I attach a letter responding to the application reference number K/33/17/HH for the ancillary accommodation at Fynings, Middleway, Kingston Gorse,

Re Planning Application Reference Number K/33/17/HH

We set out below our comments on the revised application for the ancillary accommodation at Fynings, Middleway, Kingston Gorse.

Drawing: LOCATION / BLOCK PLANS

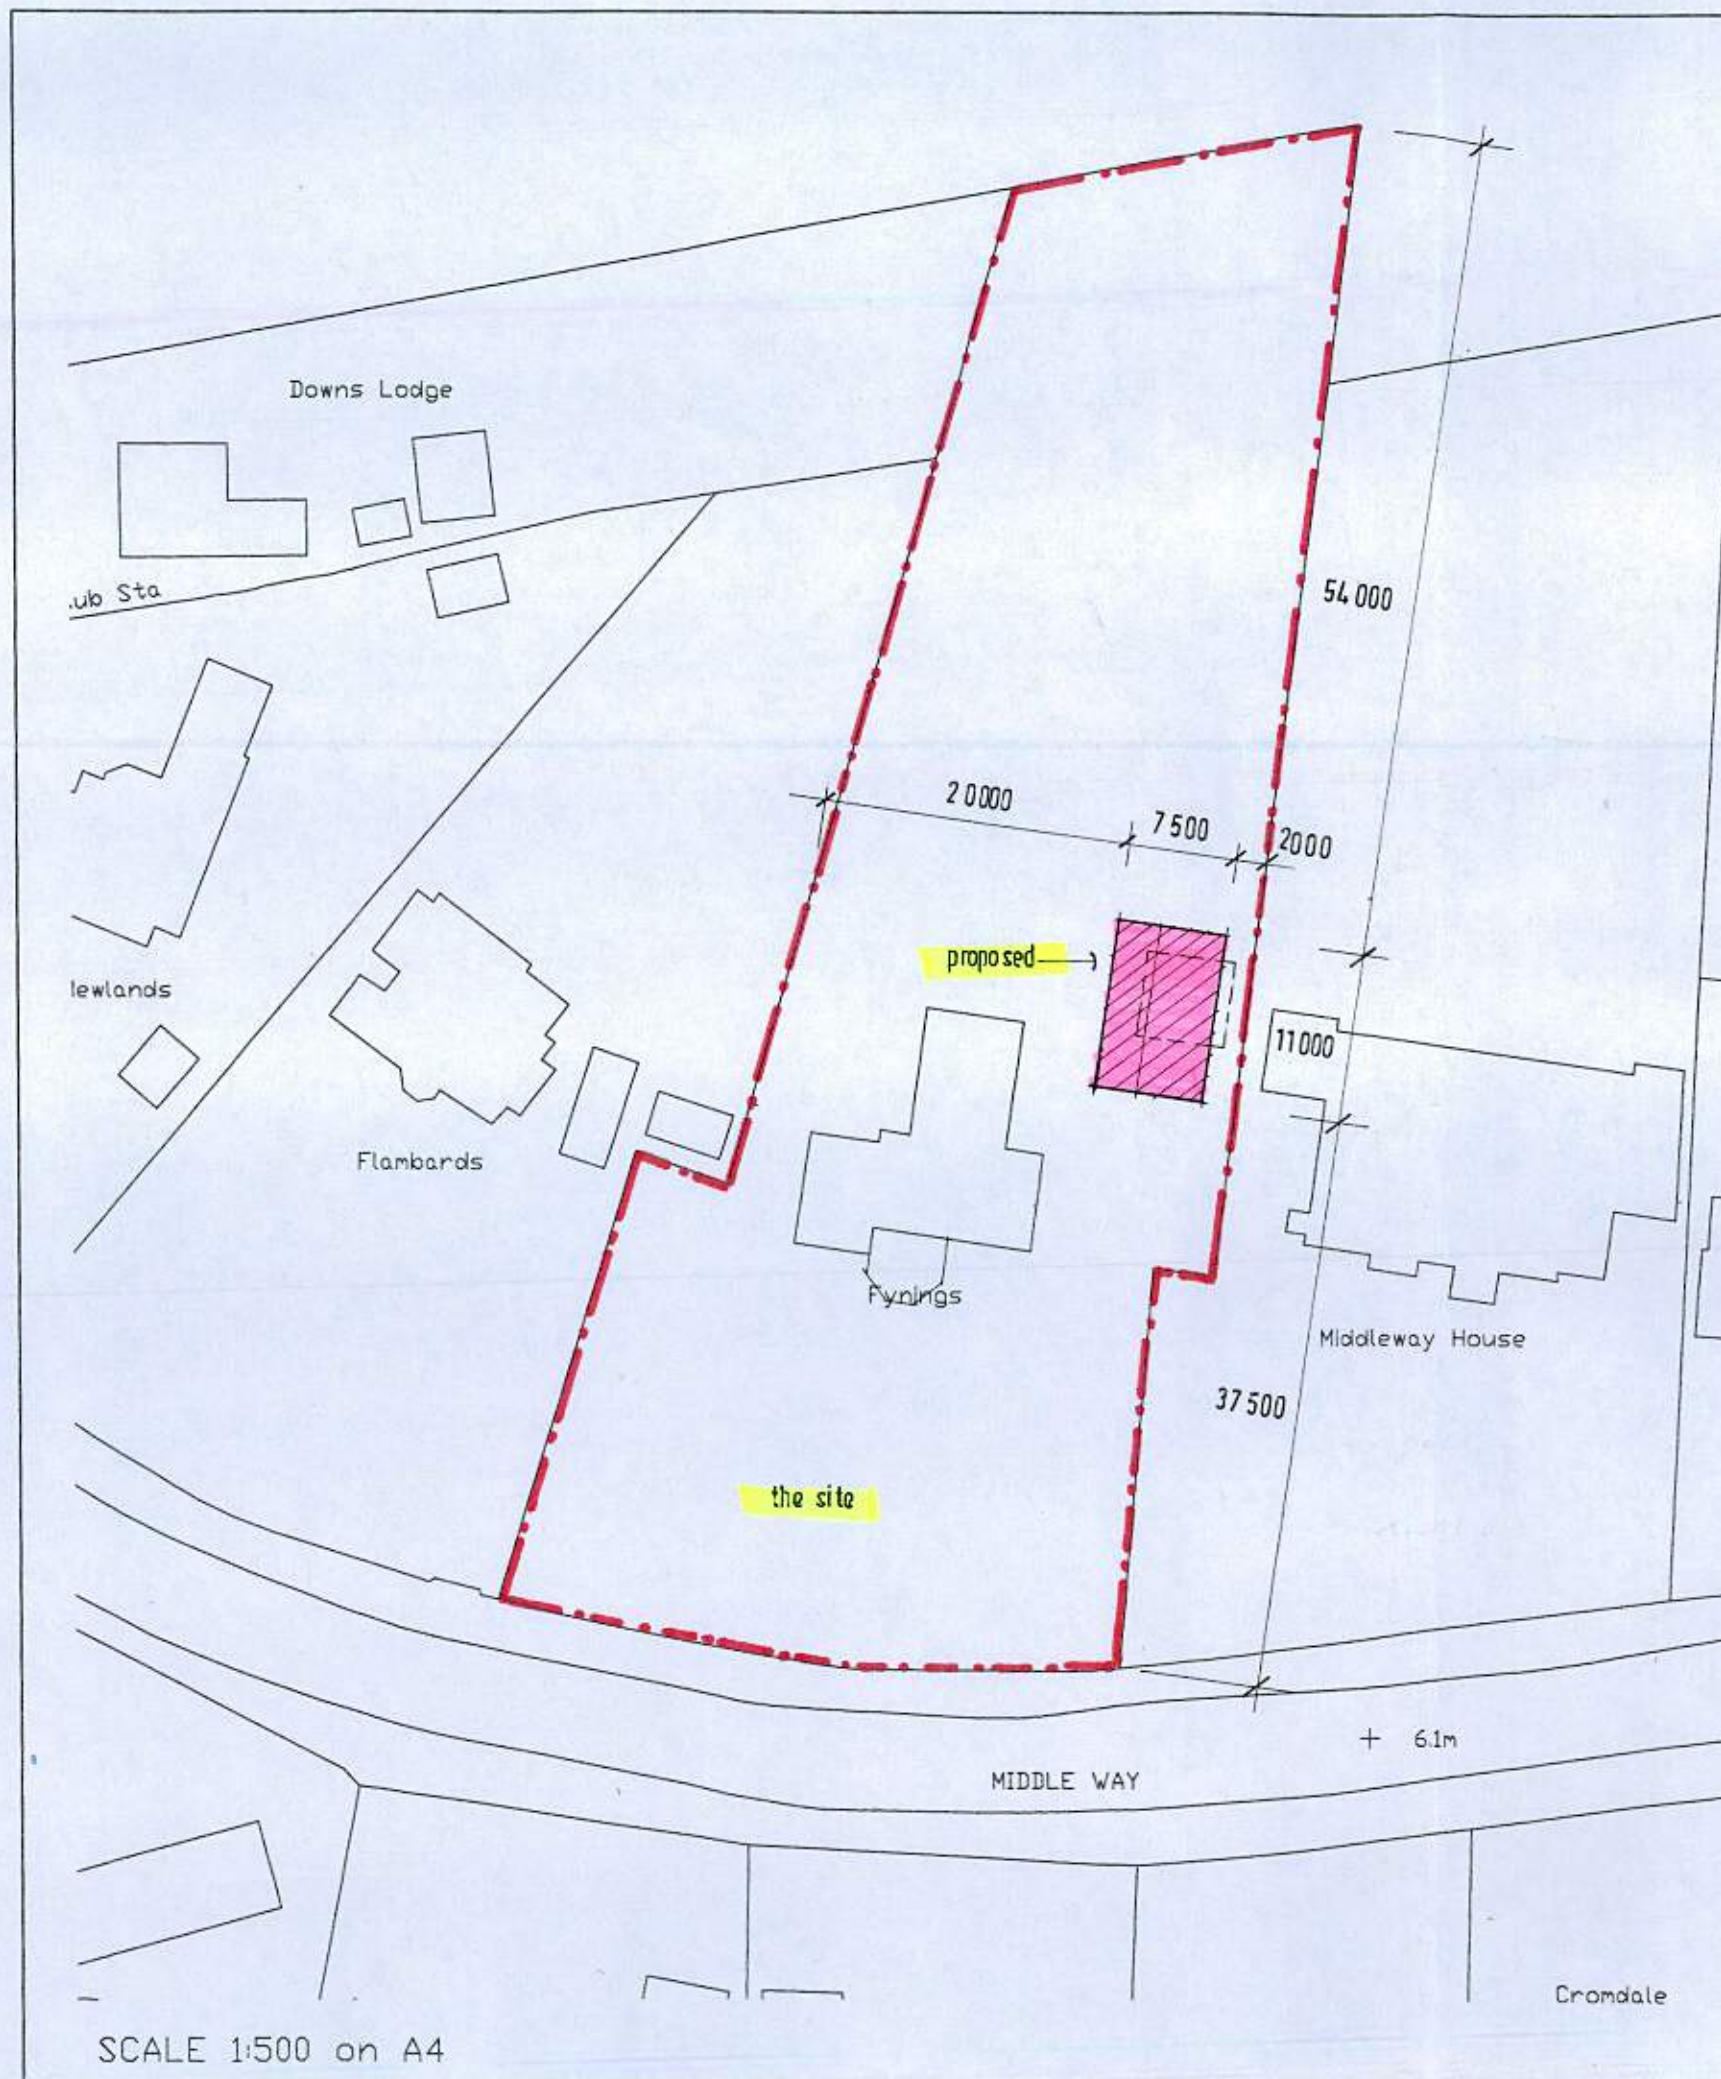
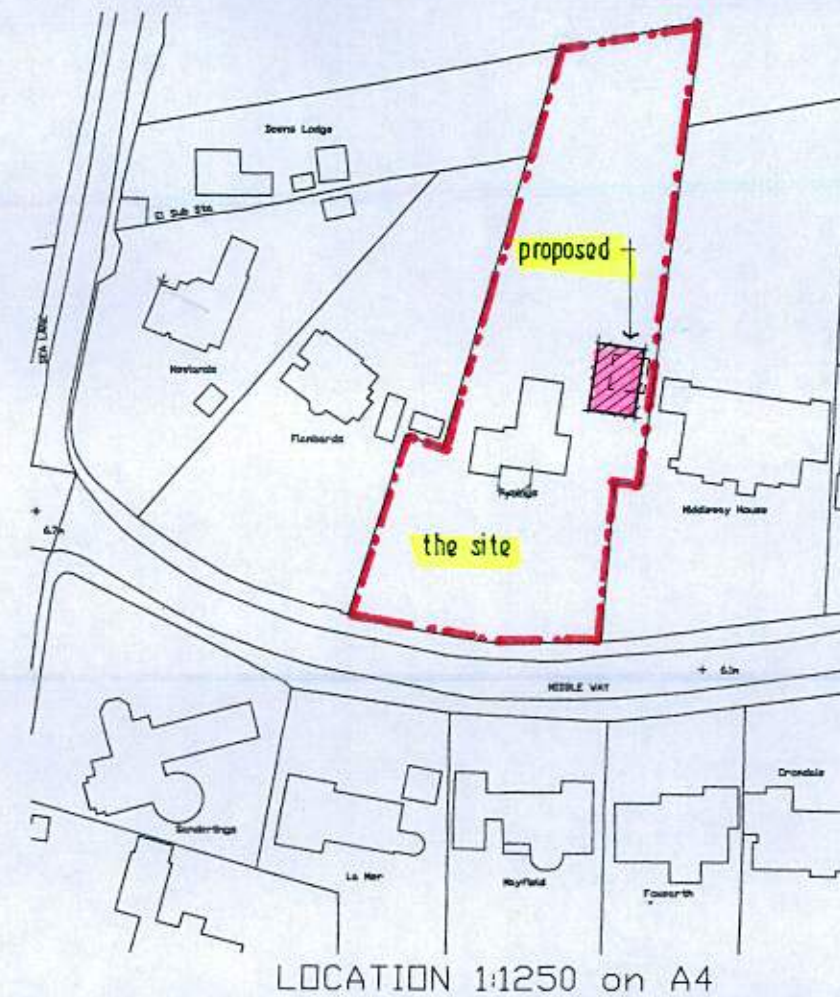
The new building is to be located 2.0 meters from the boundary wall running between our properties. Although not dimensioned it appears to be approximately 3.0m to 3.5 meters in front of the building line of the existing garage with an area of 82.5 square meters.

We are appreciative that the latest revision of the proposal is to be single storey. The revised location is however now positioned directly in front of our habitable rooms. The building has a mono-pitched roof 4.7 meters in height and this would be higher than a normal duo-pitched roof of the same pitch. It will have a substantial impact on our residential amenities especially the living spaces on the western side of our property.

Retains the position of the building as shown in the application at 3.0 meters in front of the building line of the existing garage. We would ask that it's bulk and mass is reduced

by the substitution of a flat roof, similar to those recently approved by Arun Council at Bramble Down in Middleway and Beach House in Gorse Avenue. The finished height being 3.0 meters.

1. Retains the mono-pitched roof shown on the application. We would ask that the location of the building is returned to that previously approved, that is on the front building line of the existing garage.

17/4445/4

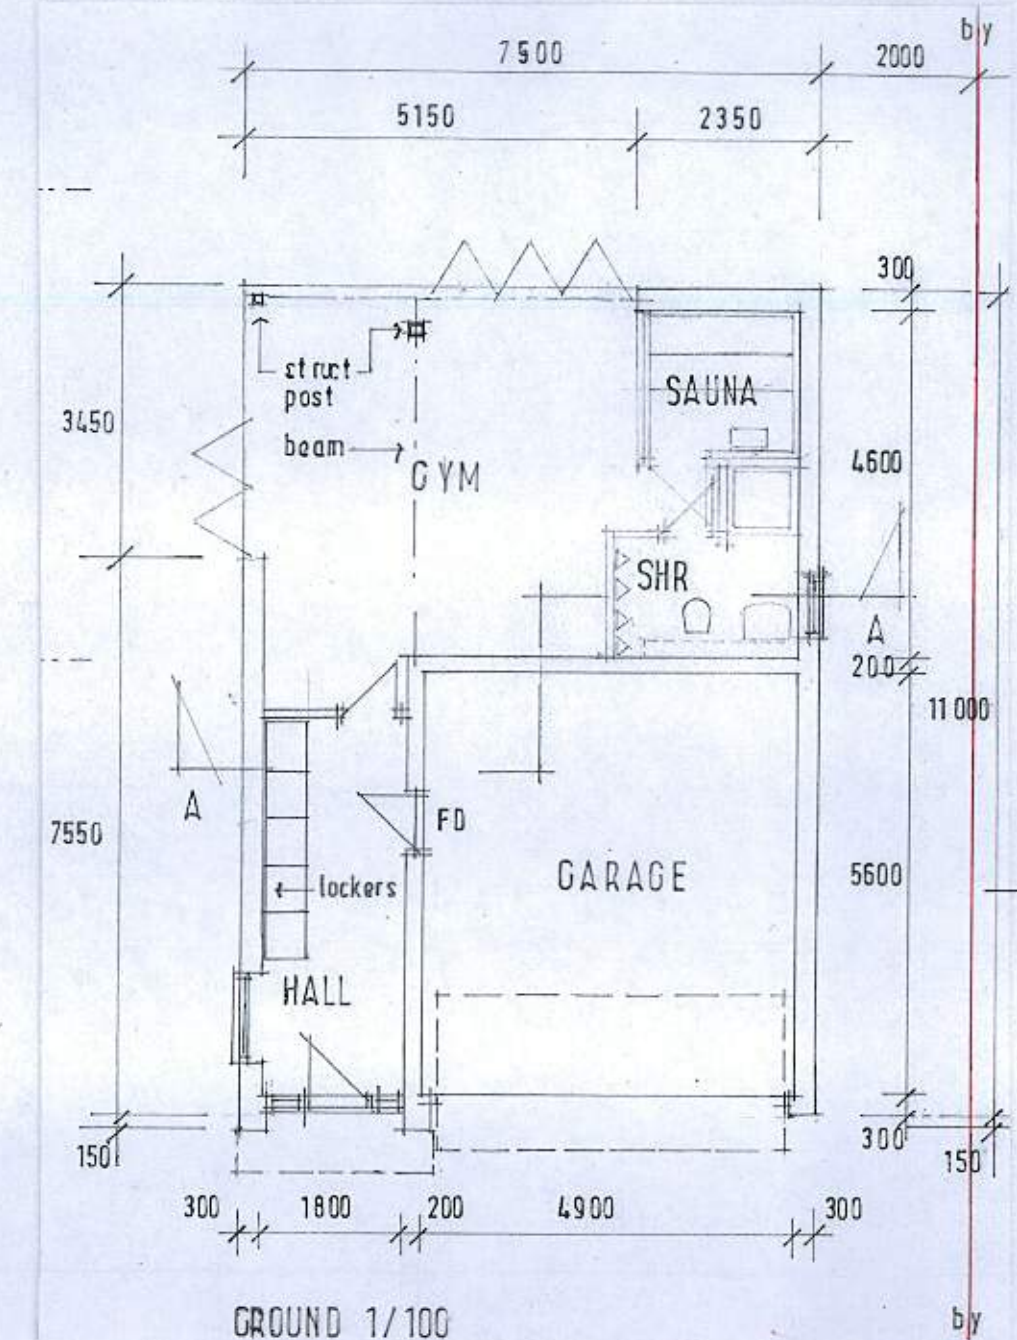
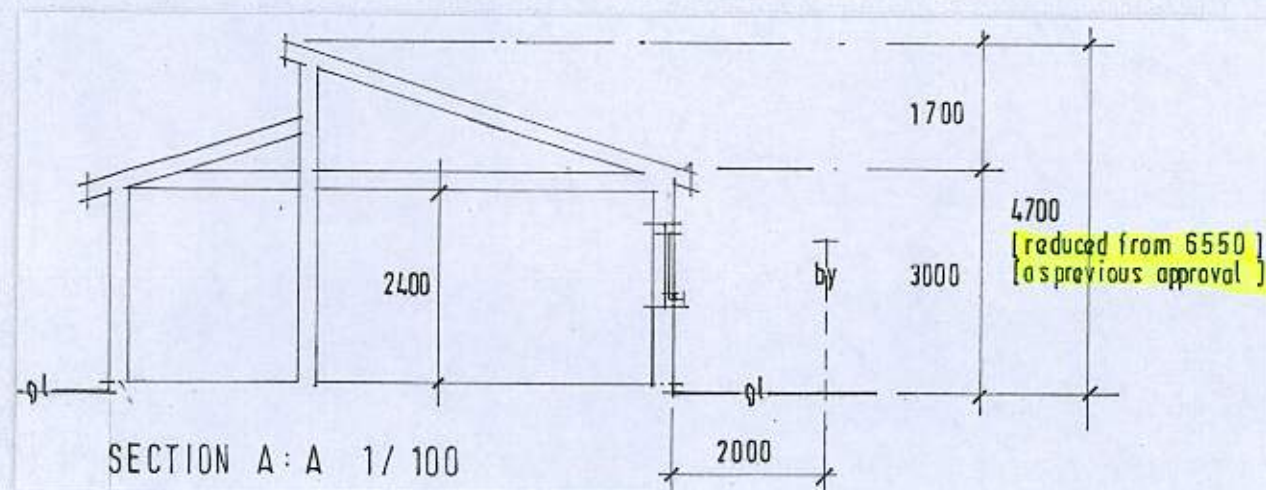
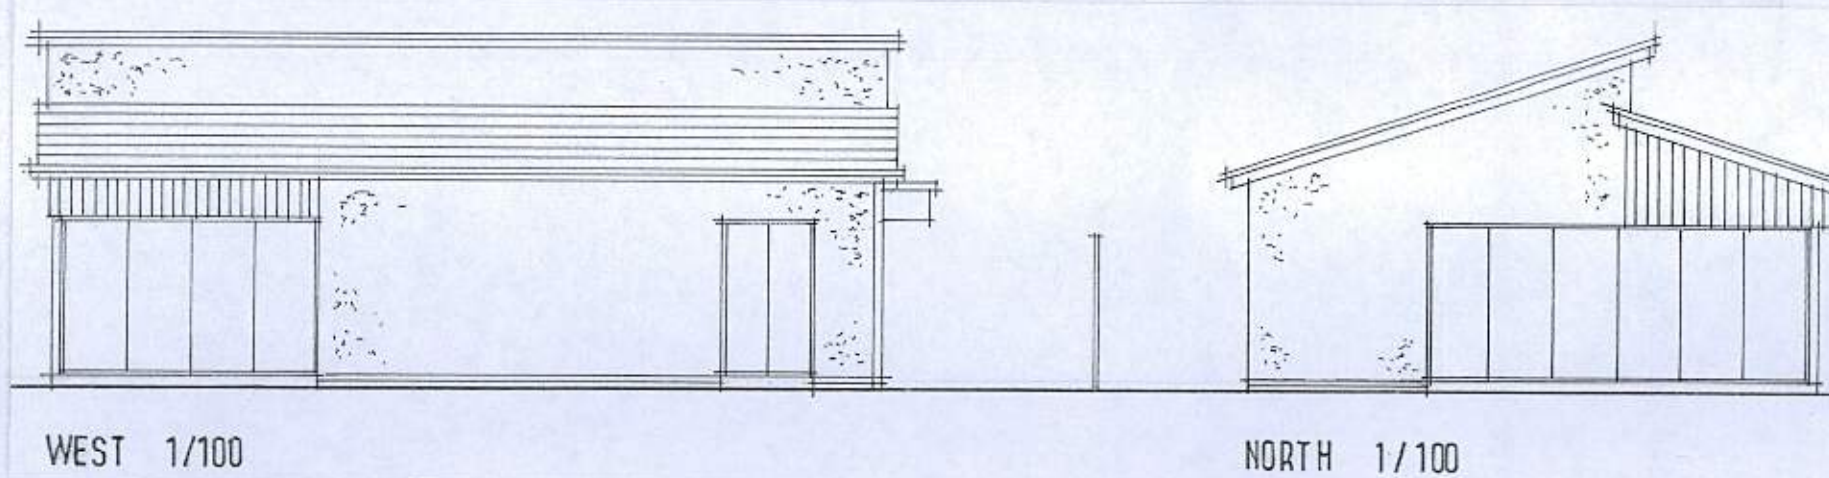
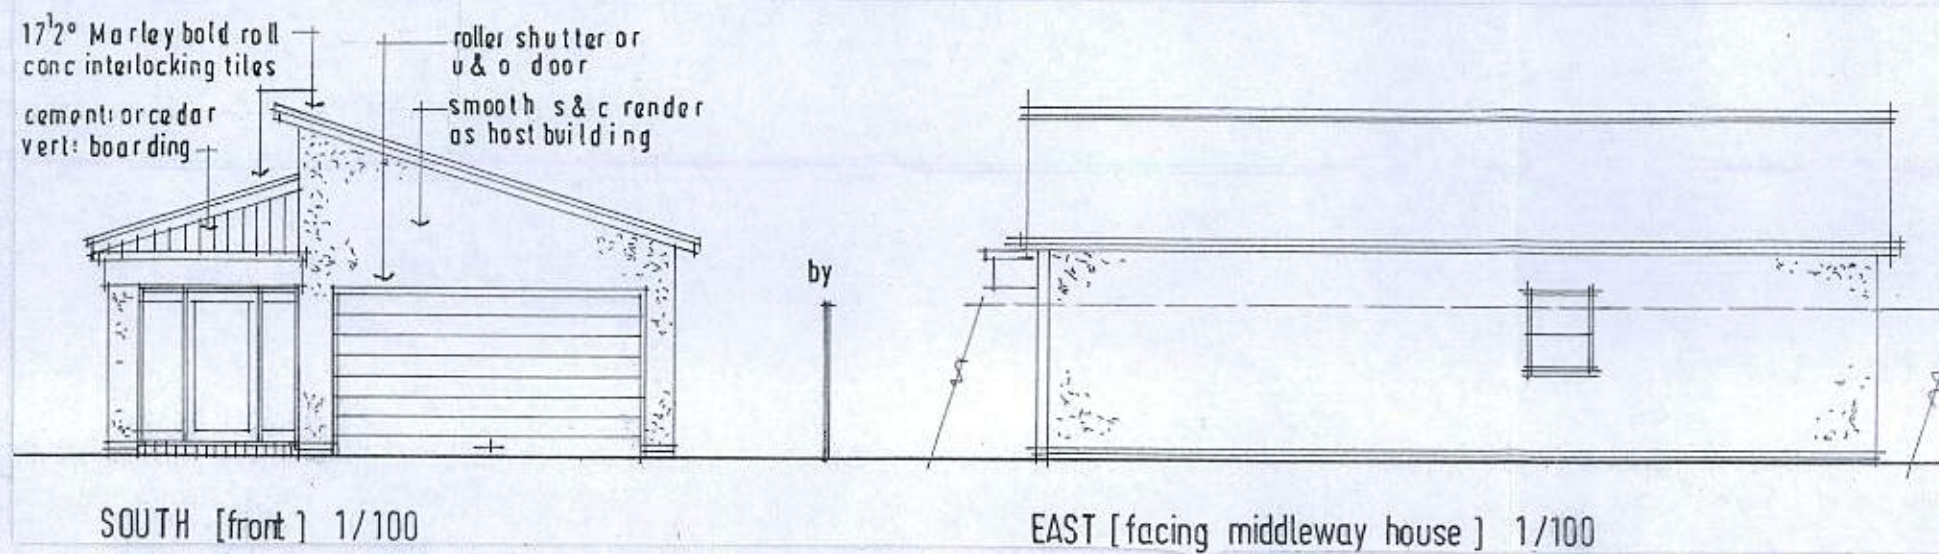
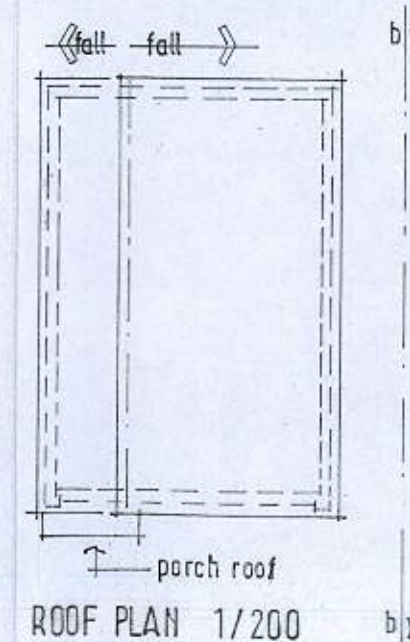
We understand this revised planning application proposes to demolish the single storey, flat roofed garage and replace it with a single storey building with a mono-pitched roof containing garaging, gym and changing accommodation.
